Application Reference: Y/70/22/DOC Site Name: Land at Blisham Road, Yapton	Initial Issue Date: 04/10/2022 Issue Date: 01/02/2024 Reviewer Reference:
---	---

Description of Works: Approval of details reserved by condition imposed under ref Y/91/17/OUT relating to Condition Nos 9 - surface water drainage and 27 - levels.

Drawing Status	FOR APPROVAL		
Client	THAKEHAM		
Project	BILSHAM ROAD YAPTON		
Drawing Title	S104-CONSTRUCTION DETAILS SHEET 1 OF 2		
Scale	NTS	Date	FEB 22
Drawn By		Checked By	
Drawing No.	D1956-15-100		
Rev.	-

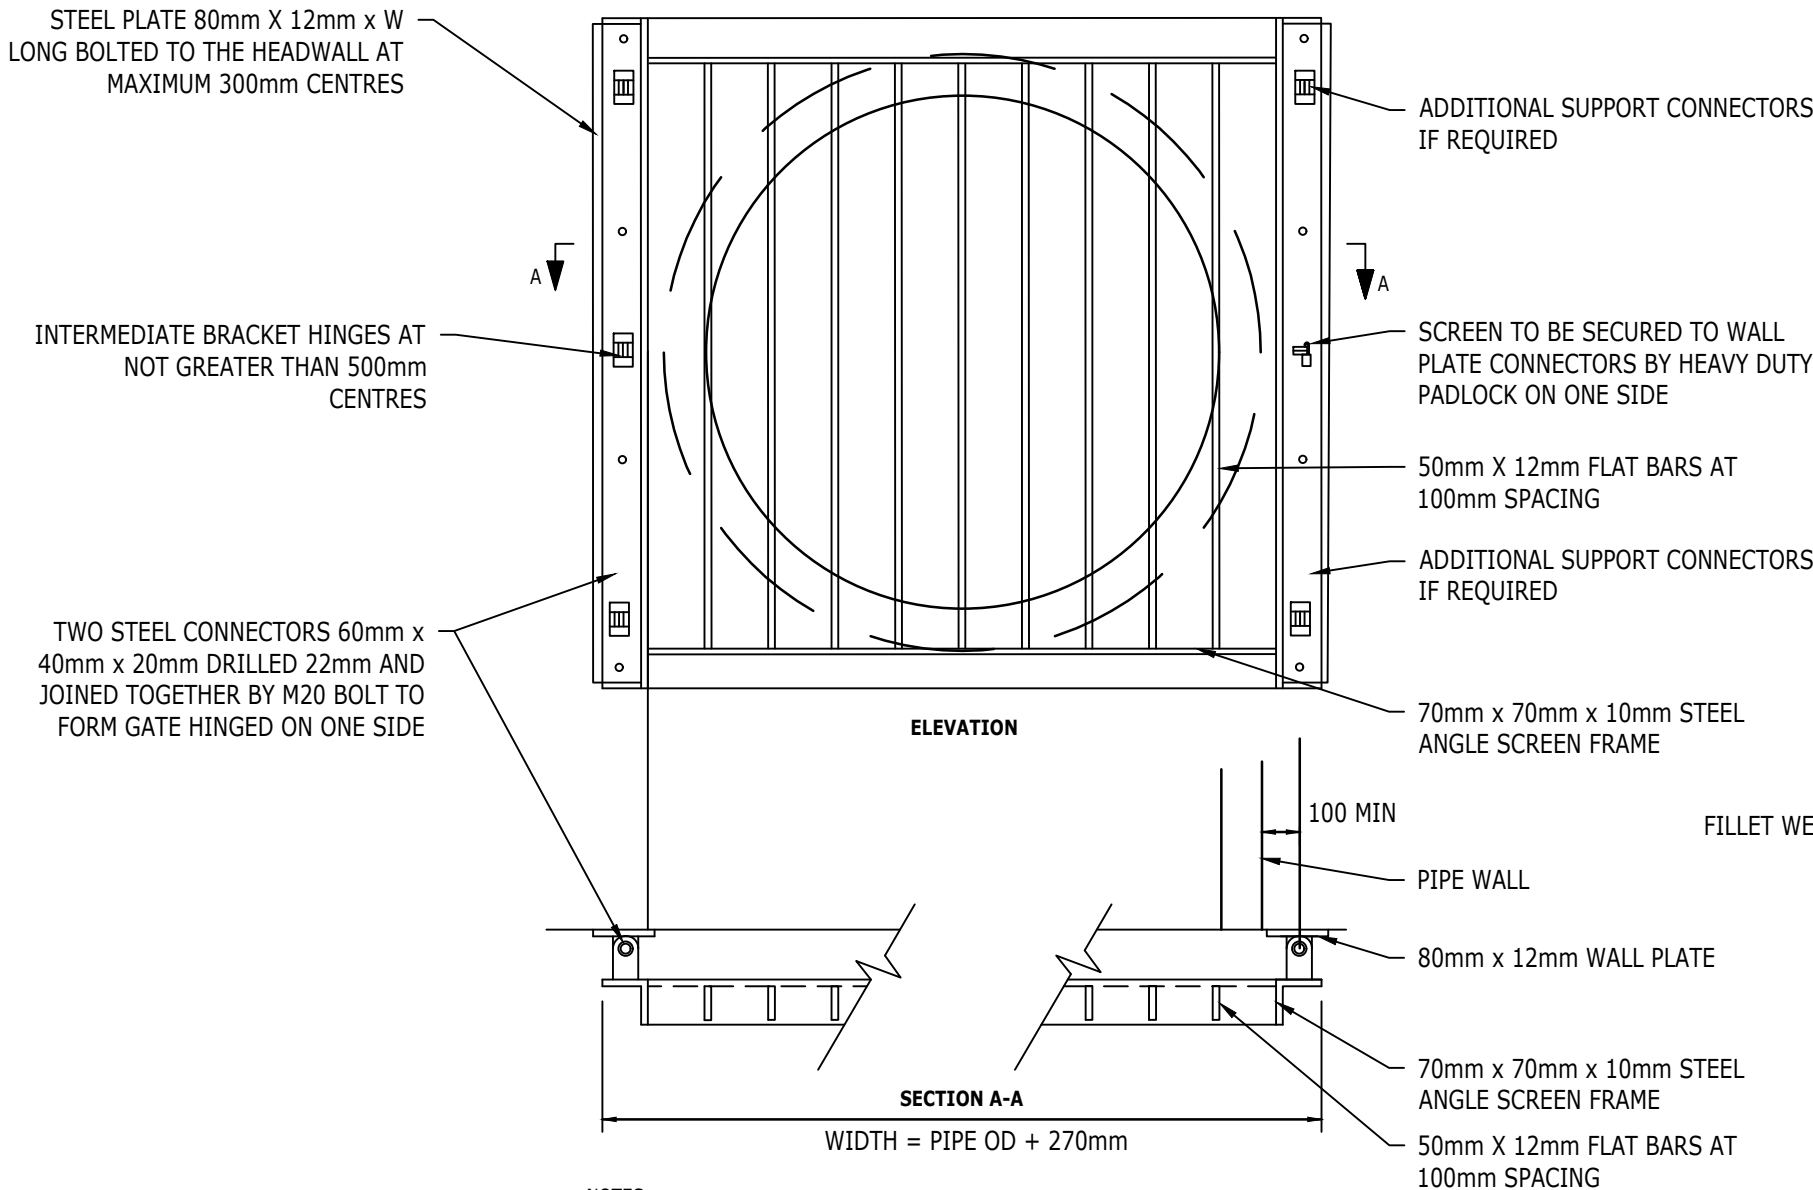
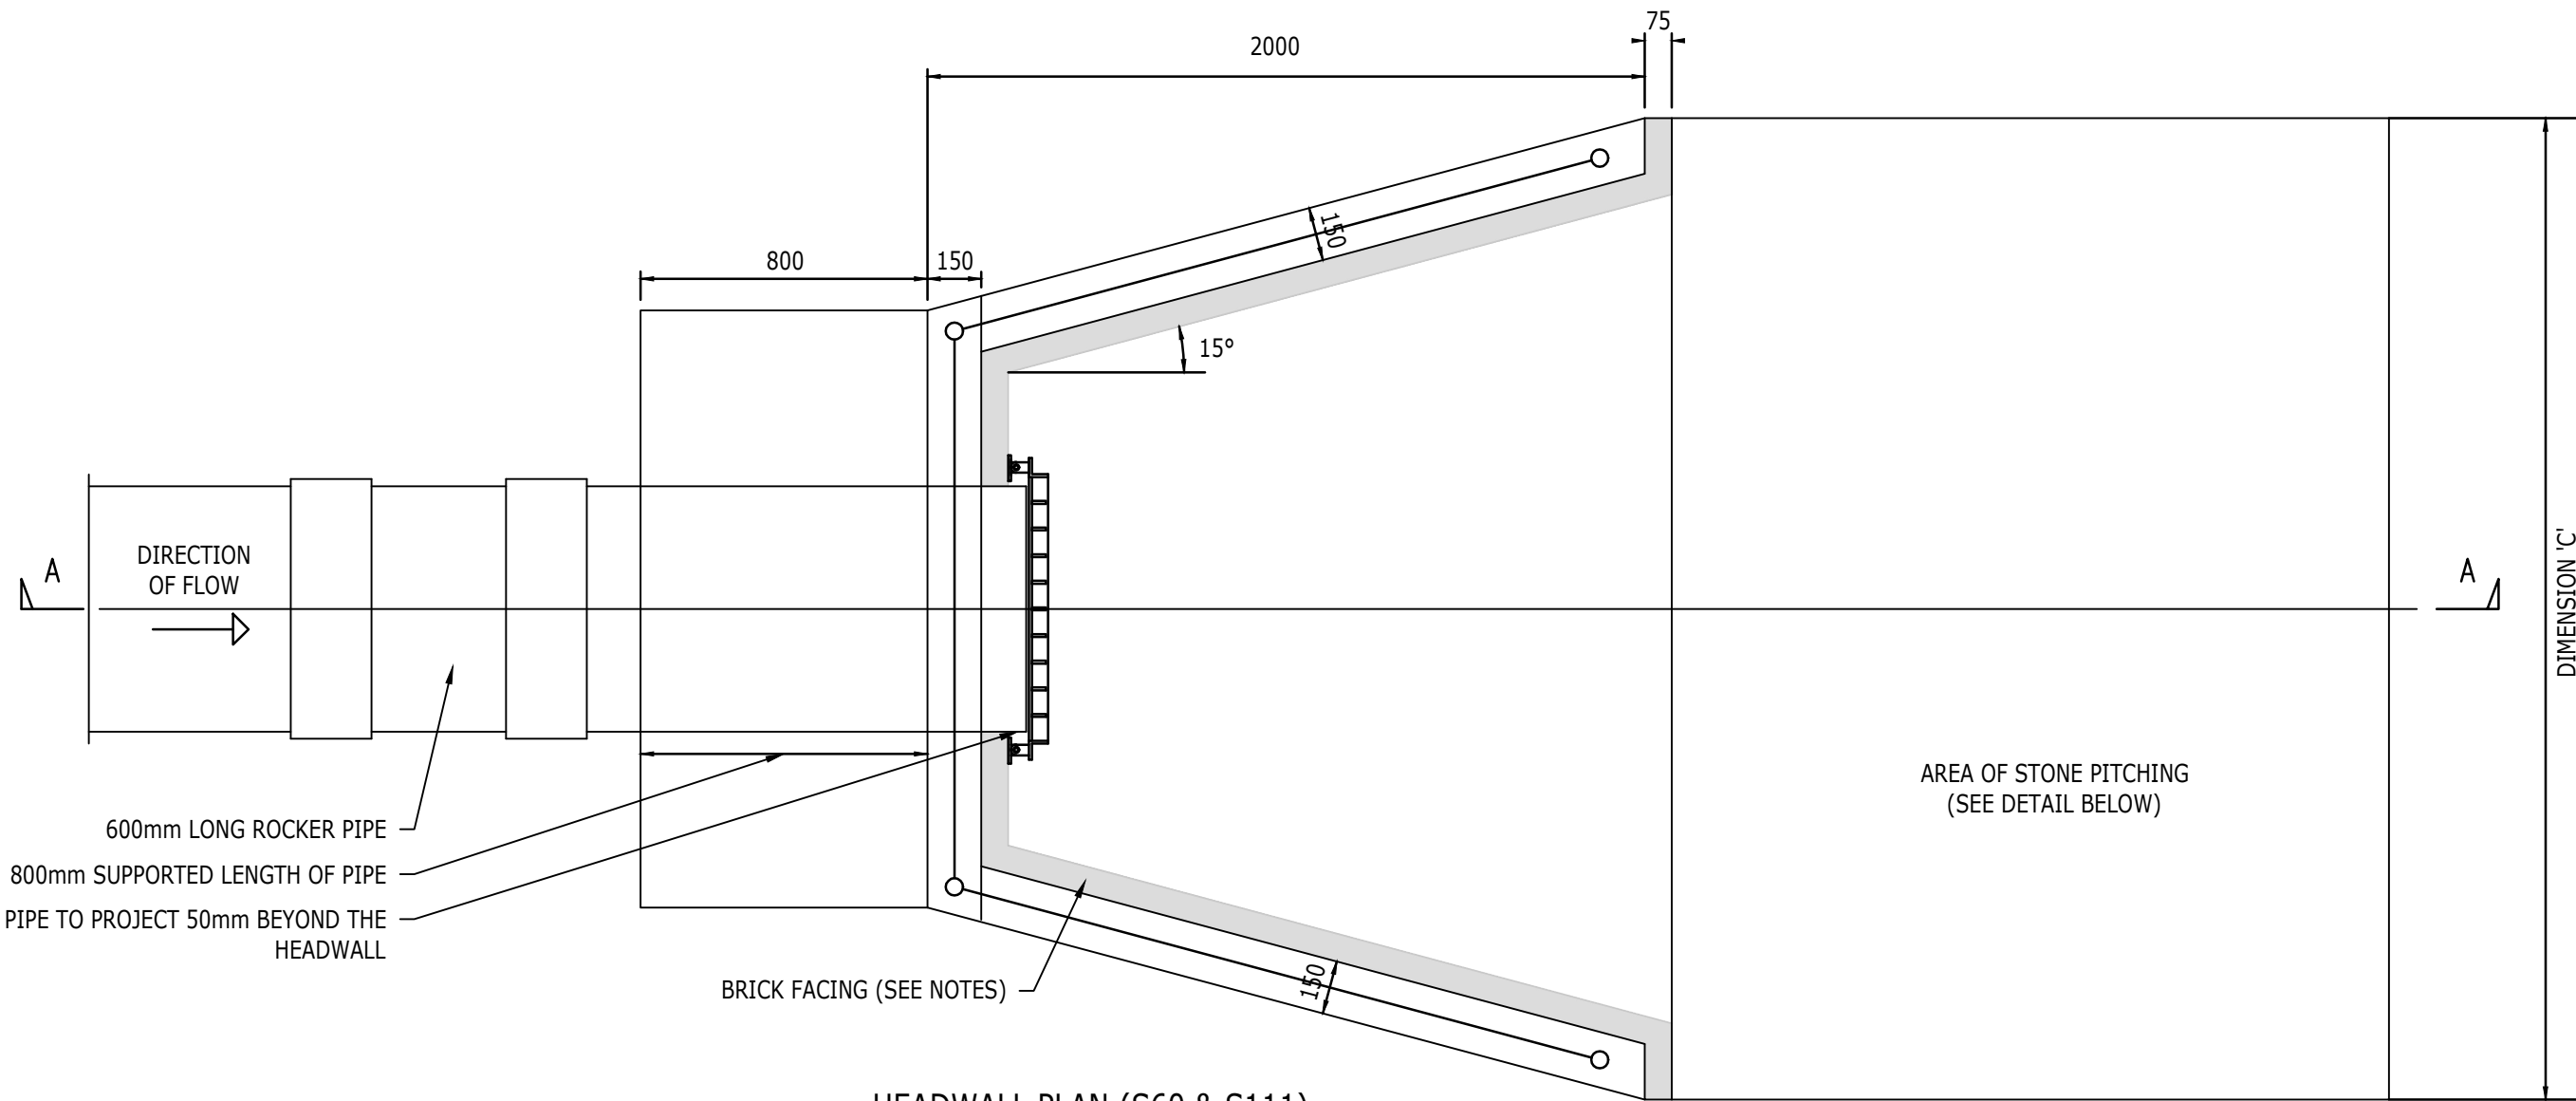
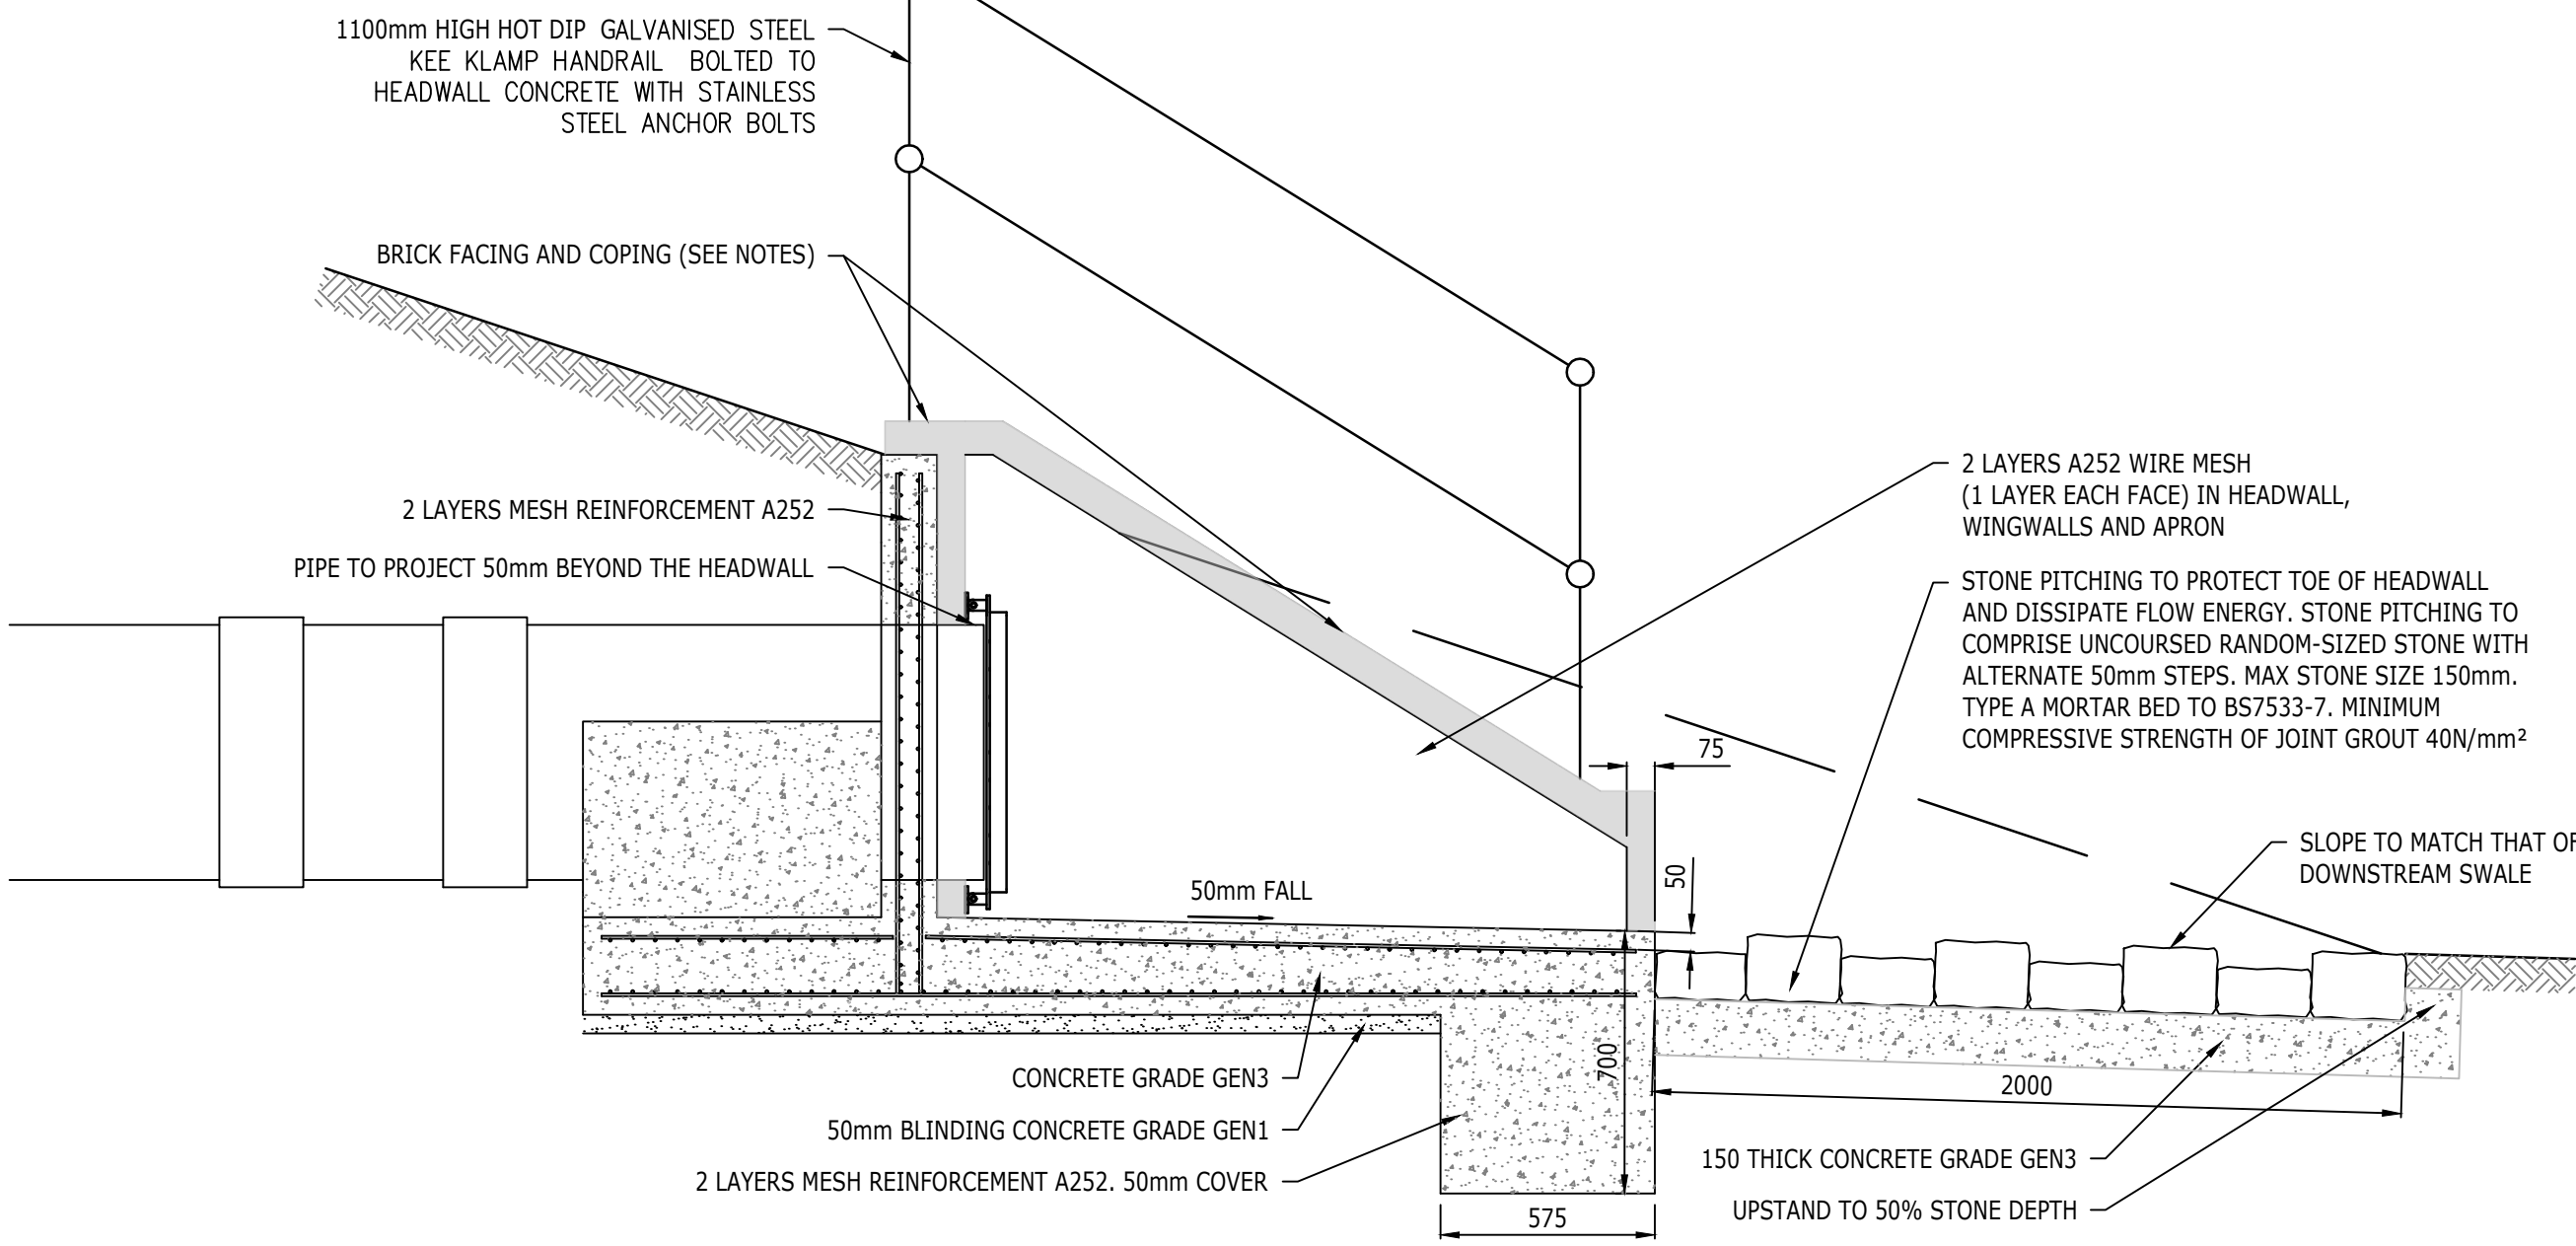
11.	Please provide cranked grilles at a 45 degree angle.	Cranked grilles required on heads – S104 Construction details sheet 1 of 2 D1956-15-100 needs to be updated to suit ADC requirement. Pipe beddings details on this drawing are illegible in parts. Information needs to be clearly presented. We note that applicant’s response that this is not “DSG compliant” however the drawings refer to Sewers for Adoption 7th Edition. As such the applicant needs to be clear which edition of Sewer for Adoption the adoptable drainage is being designed to. In addition they should confirm who the adopting authority will be as well as confirmation from the adopting authority on whether they will or will not accept cranked grilles. 08/02/2023- Whilst is noted that the Technical Approval certificate has been provided for information, this doesn’t clarify whether the adopting authority has	Accepted by the LPA as designers risk,– Now closed

considered a request to use cranked grilles. This needs to be confirmed by the adopting authority otherwise cranked grilles should be used. 09/07/2023 – We await your submission of the confirmation from the adopting authority or as previously advised this should be amended to meet the requirements of Arun District Council.
